Application no: H17-0290-11

Description: Proposed two-storey extension

Location: 6 Scoldhall Lane
Surfleet
Spalding
Lincs
PE11 4BJ
PE11 4BJ

Amendment: Addition of pitched roof (dwg. nos. SUR/10/07A and SUR/10/08A)

REAR ELEVATION AS PROPOSED

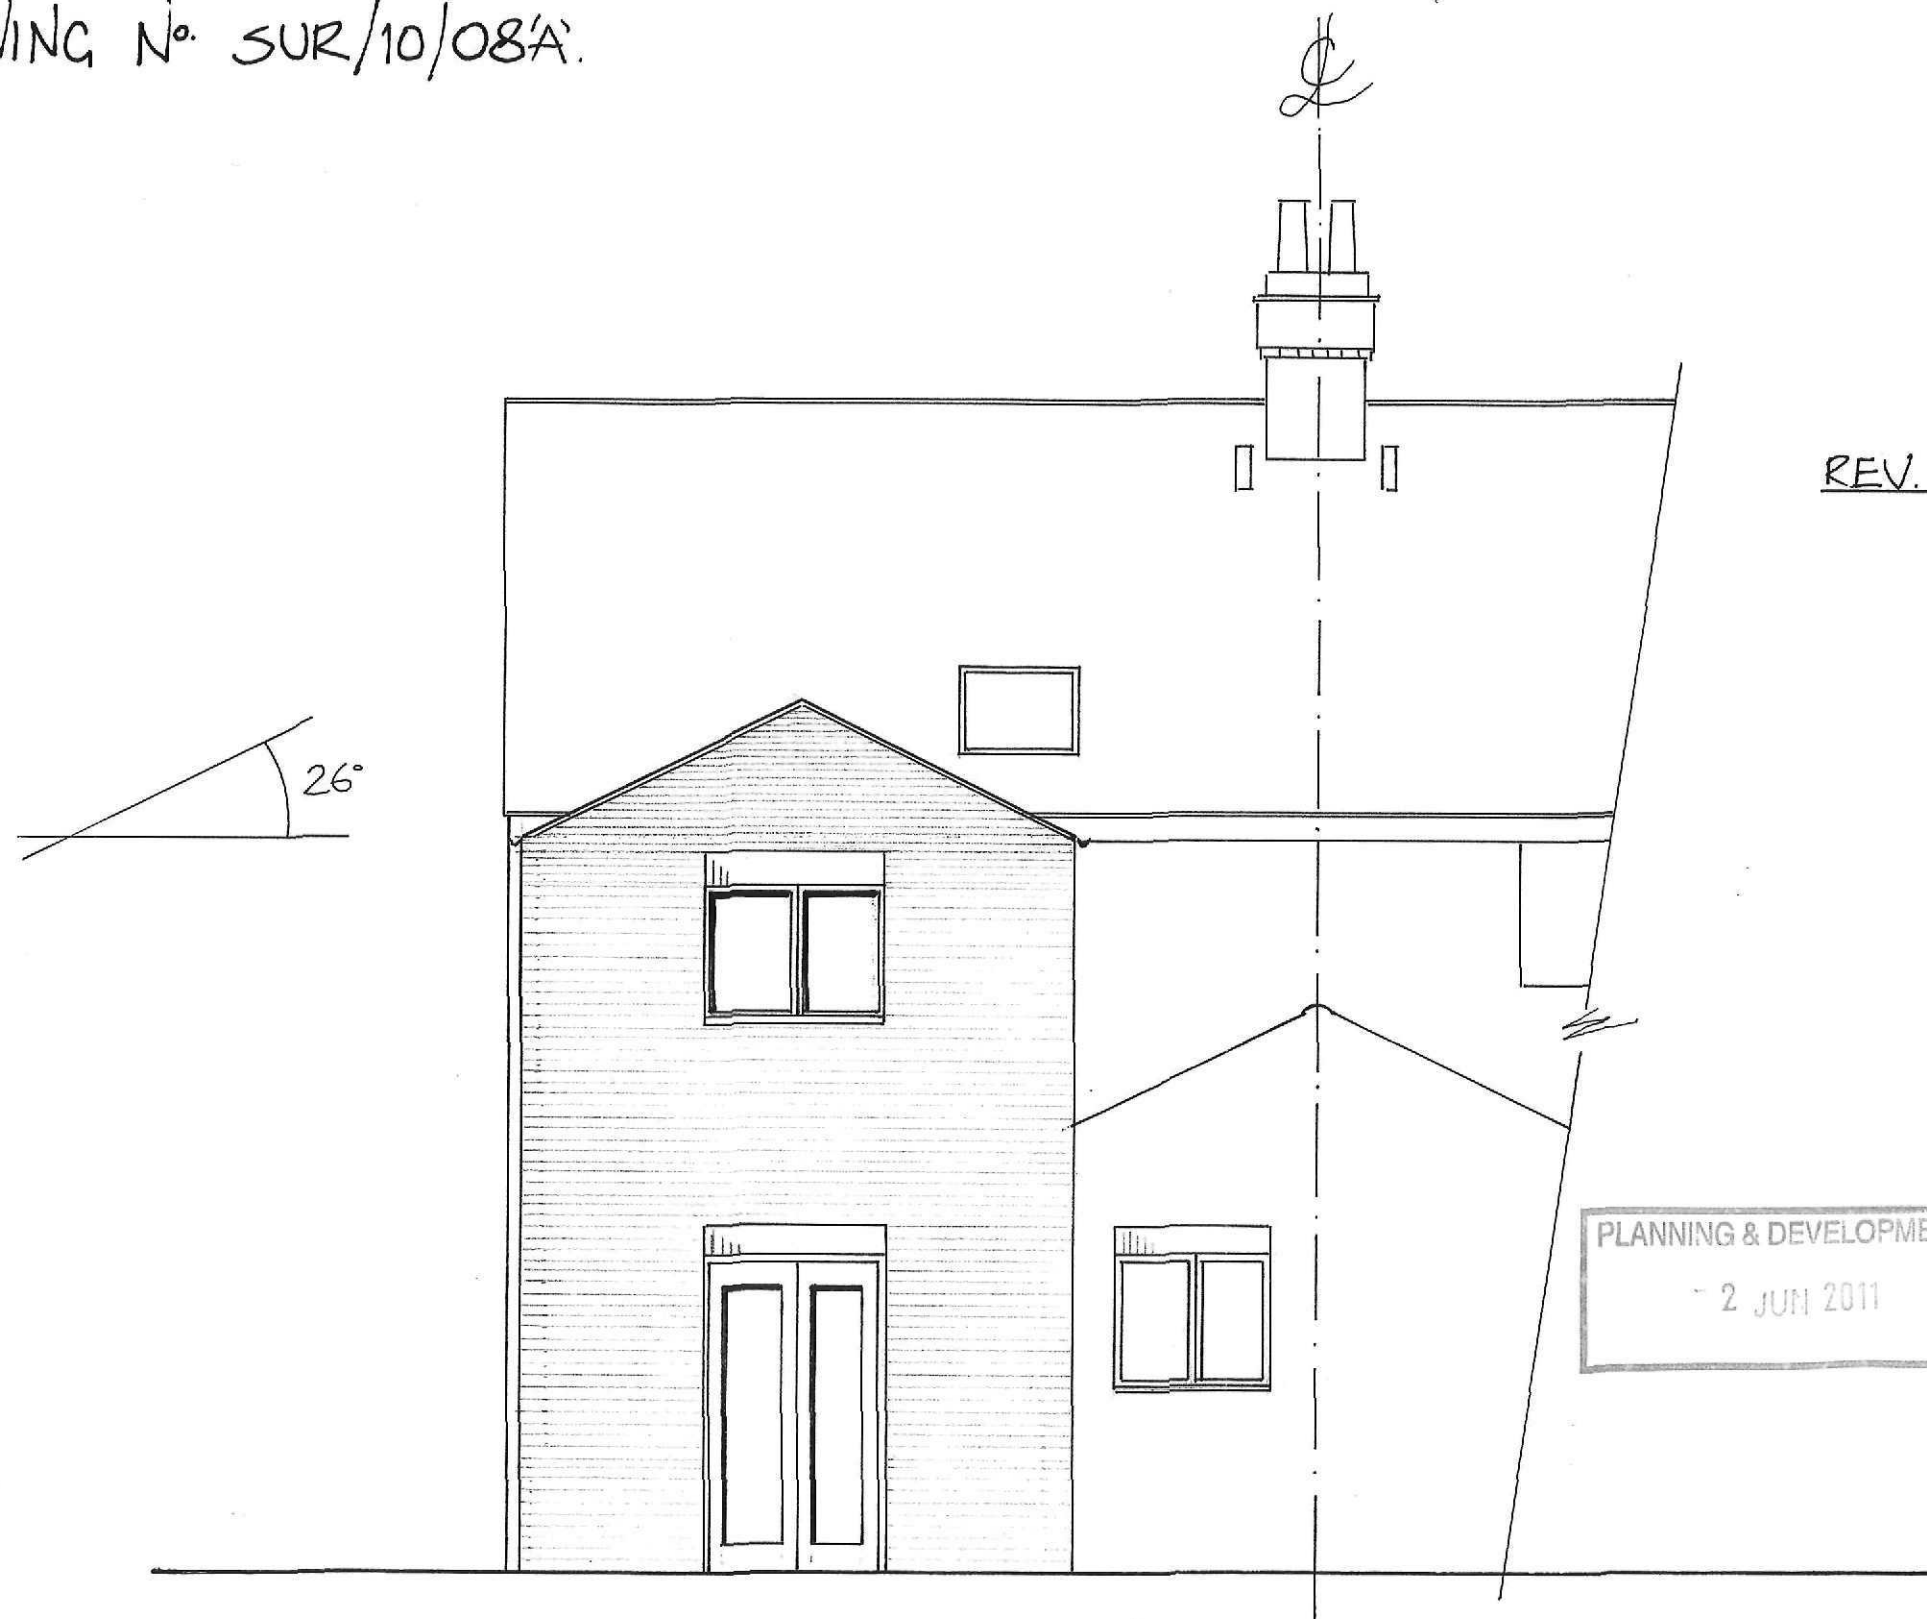
Hi Tracy,
Further to our conversation last Wednesday I have added a pitched roof as requested. I have set it at an angle to match the single storey roof which coincidentally is also the absolute minimum pitch for laying slate. Slate was the original material for these houses and so this is what I propose to use on the extension. I gave a draft set of the amended drawings to our adjoining neighbours for comment but have not received any response.
